Re: Parramatta Powerhouse Heritage Impact Statement

The National Trust strongly object to the inadequate heritage impact assessment undertaken for St George's Terrace as part of the Parramatta Powerhouse proposal (SSD-10416).

The heritage impact of the revised design needs to be appropriately assessed as part of the planning process. The National Trust wishes to raise its concerns with the recently tabled *Addendum Statement of Heritage Impact – St George’s Terrace* (2 November 2020) prepared by Advisian.

1 DEMO ELEVATION W  
1 : 50

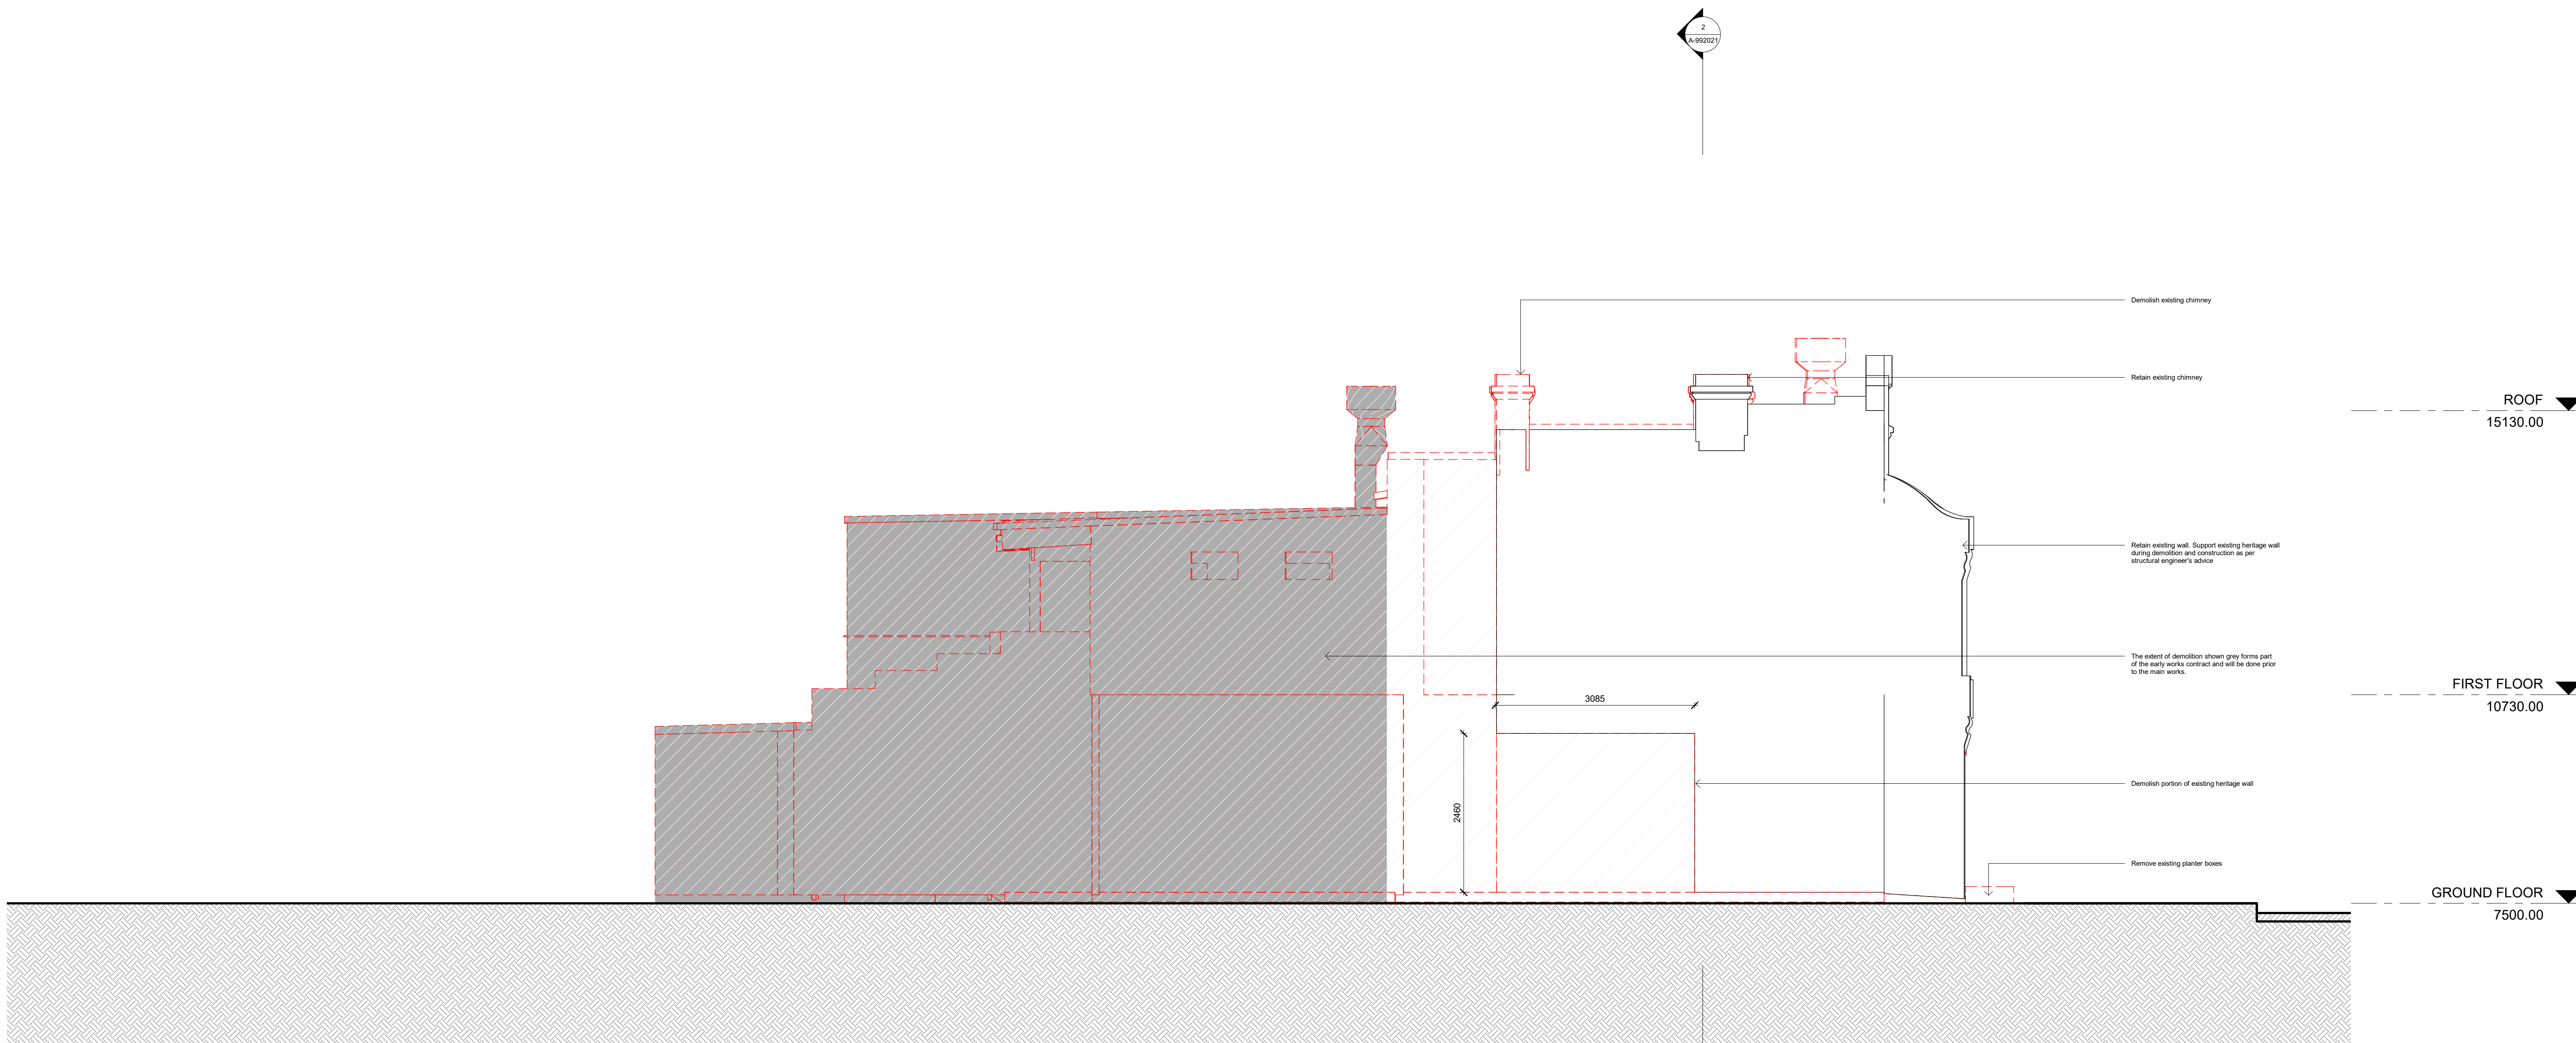
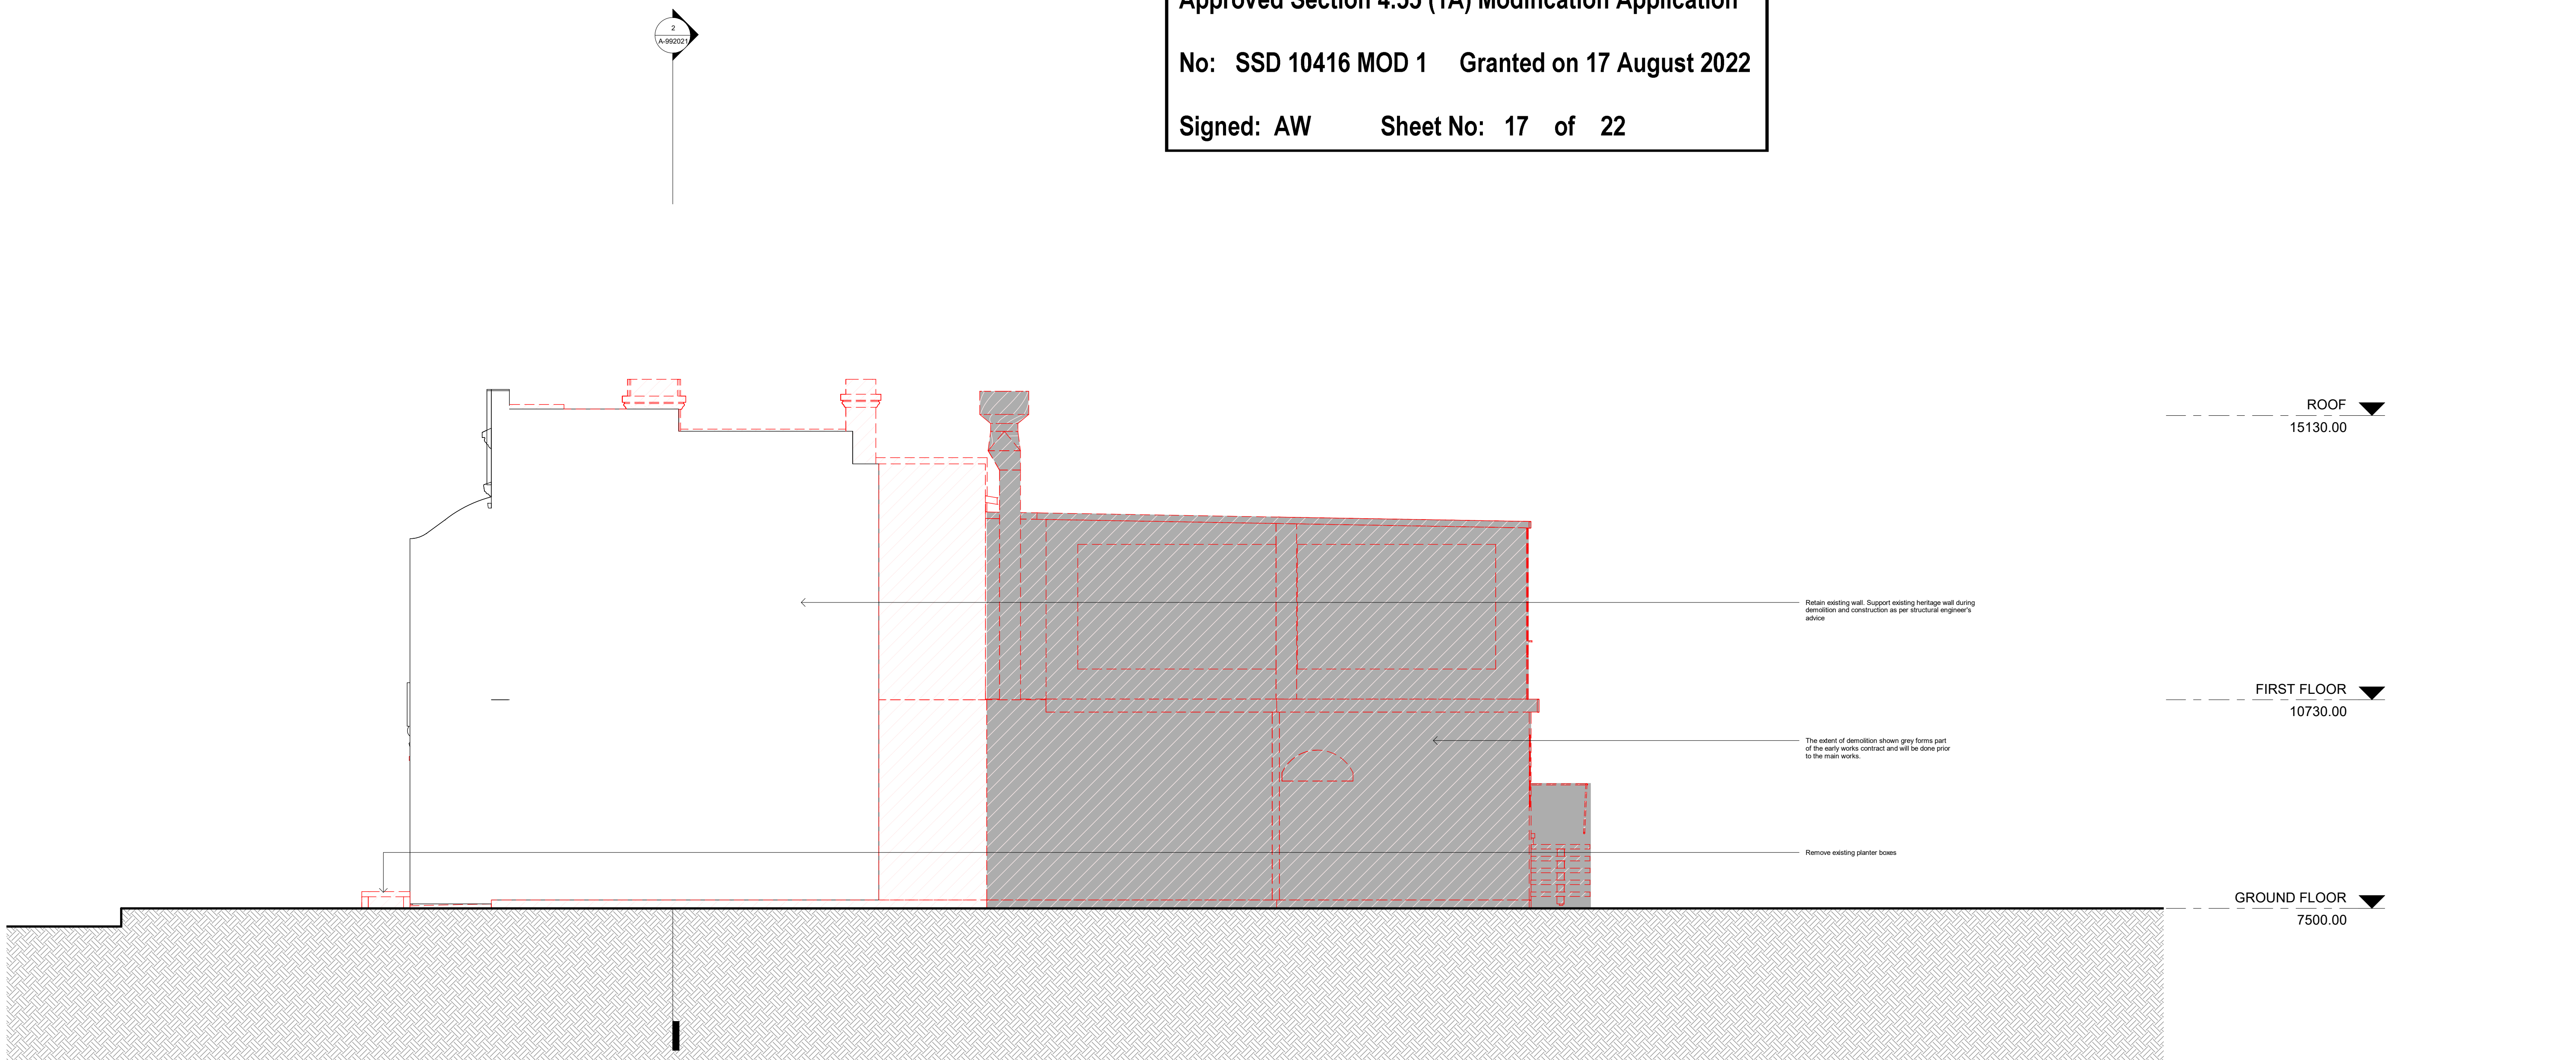
Is the demolition essential for the heritage item to function? Partial demolition to the heritage item is limited to approximately 1.688 metres of the original brick structure (to the east and west elevations)... The demolition is required to enable construction of the Powerhouse Parramatta. This would allow for the retention, conservation and adaptive reuse of most of the original brick structure fronting Phillip Street as part of the Powerhouse Parramatta (p.20)	Nowhere does the report clearly identify the extent of demolition or make an assessment of this. Any new building could (and must) be designed around the existing historic structure. Demolition should not be necessary to build the new building. No reasons have been provided as to why this is not the case.

<p>Is the detailing of the partial demolition sympathetic to the heritage significance of the item? The demolition of a small section of original fabric is sympathetic to the item as it facilitates the retention of the traditional form and height of St George's Terrace when viewed from Phillip Street. (p.20)</p>	<p>This is an inadequate assessment. The demolition of original fabric needs to be clearly identified and assessed.</p>
<p>Why is the new development required to be adjacent to a heritage item? Due to the location of the site next to the river, museum buildings are set back from the river to address flood constraints. As a consequence of these features and constraints, the new development is required to be adjacent to a heritage item. (p.21)</p>	<p>The inappropriate siting of the new museum is not considered an adequate reason to justify impinging on a heritage item.</p>
<p>How does the curtilage allowed around the heritage item contribute to the retention of its heritage significance? The curtilage of St George's Terrace contains all fabric that contributes to heritage significance (p.21)</p>	<p>The consultant clearly has no knowledge of what heritage curtilage is. Are they saying that St George's Terrace actually contains its own curtilage? There is no assessment of the impact on the curtilage of St Georges Terrace.</p>

The National Trust request that a legitimate Heritage Impact Statement for the proposal be prepared by a suitably qualified and experienced heritage practitioner that adequately assesses the heritage impact of the proposal.
